Create first floor in existing garage for additional bedroom and home office  
19 St Marys Meadow Yapton

Thank you for your internet representation made on 22nd May 2019 which has been recorded as '**an objection**' with the comments as follows:

REVISION:- A	DRAWING NO:- MT / 1547 / 2
--------------	----------------------------

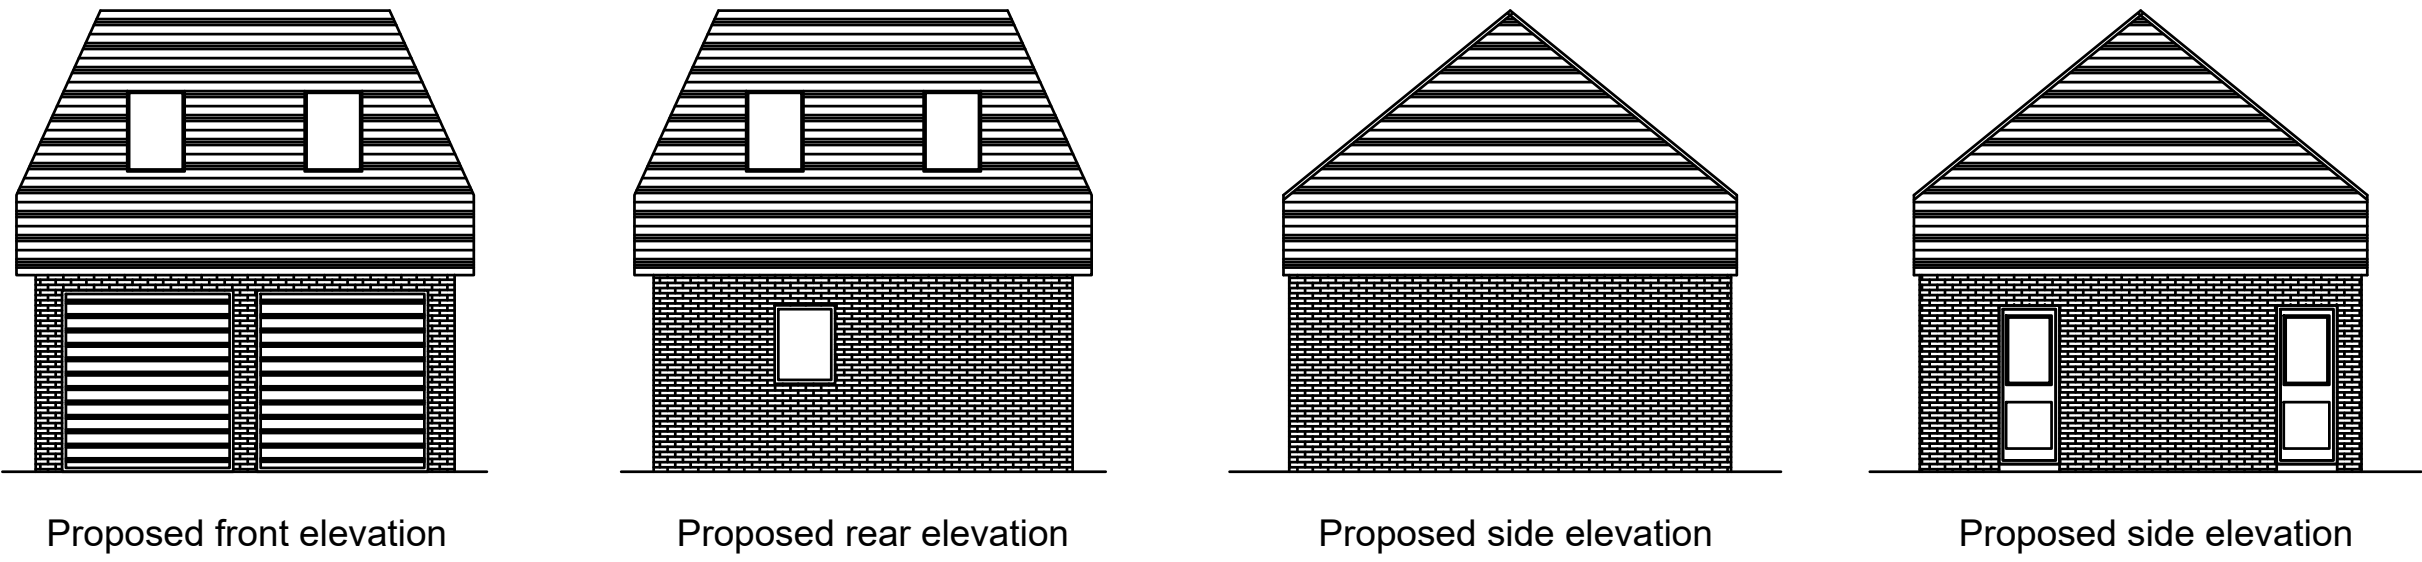
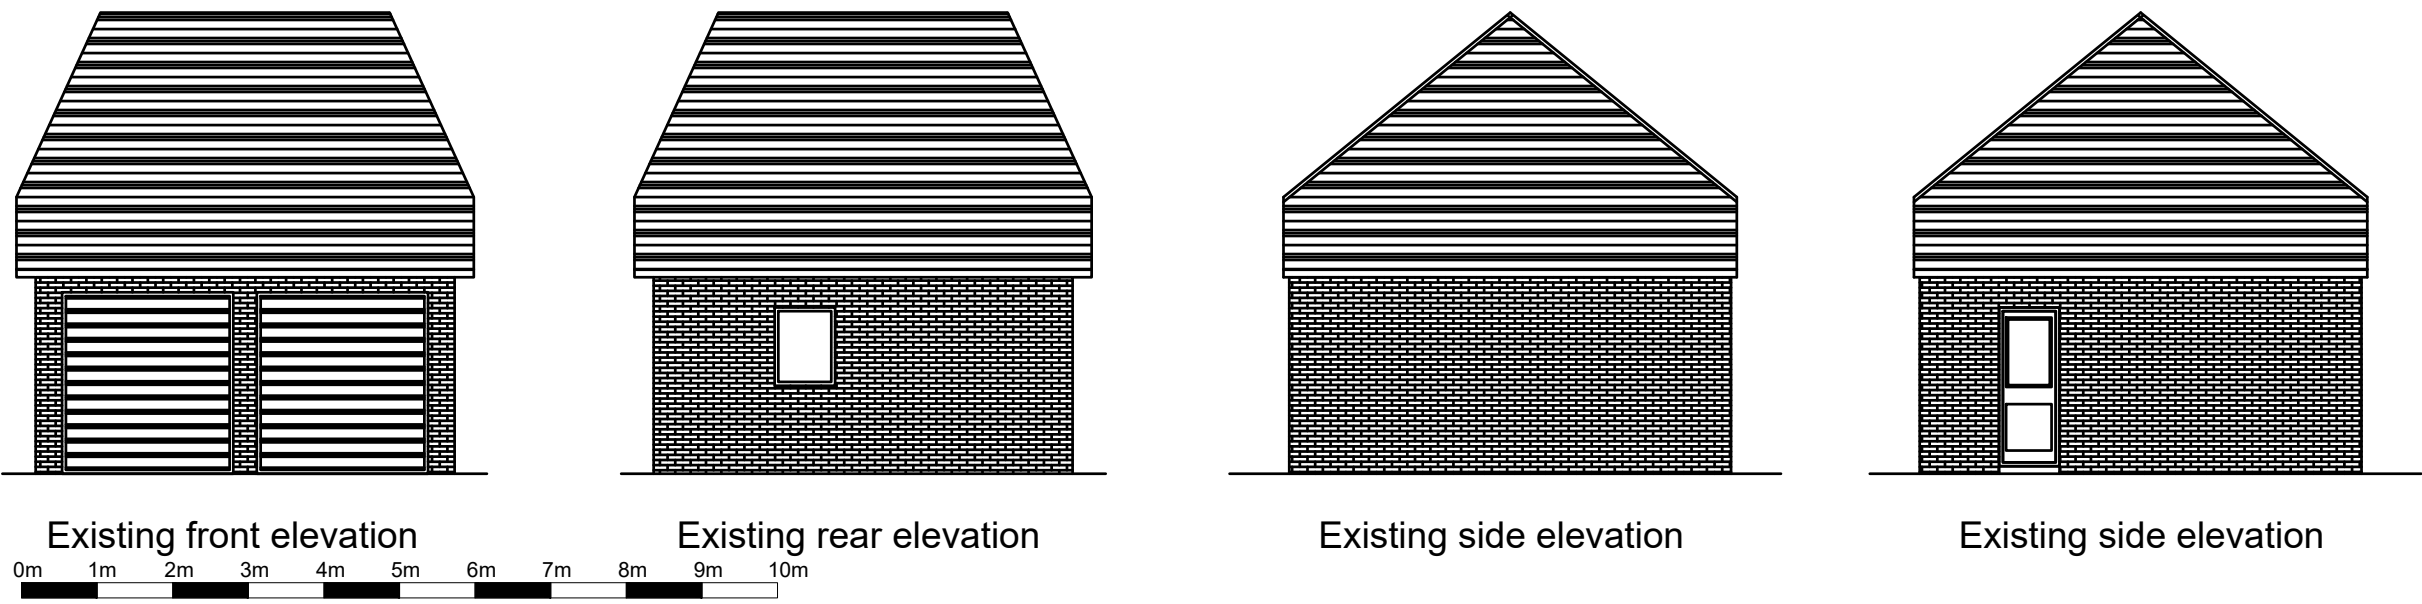
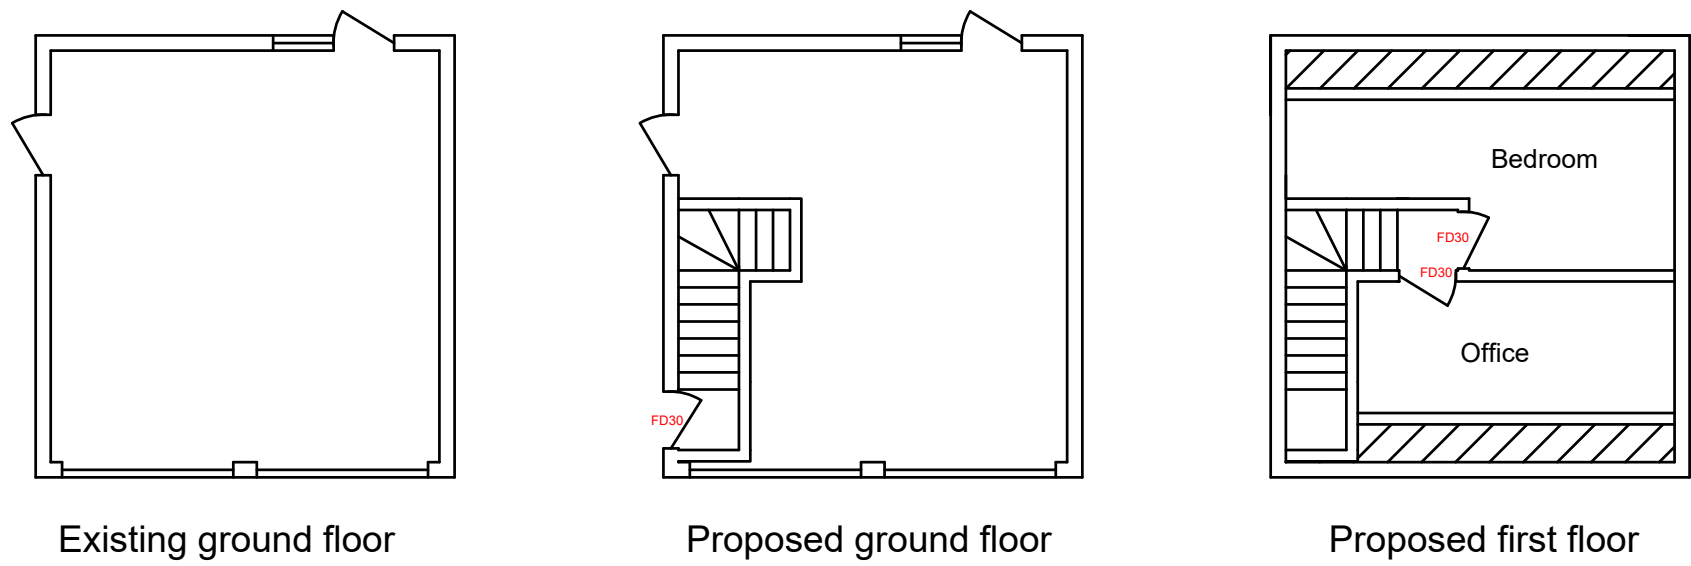
*Privacy issues may arise depending on the position of the windows and their proximity to neighbouring property rooms on ground and first floor. This may be reduced if the windows installed are strictly "skylight" only with frosted glazing as a further option to be considered?*
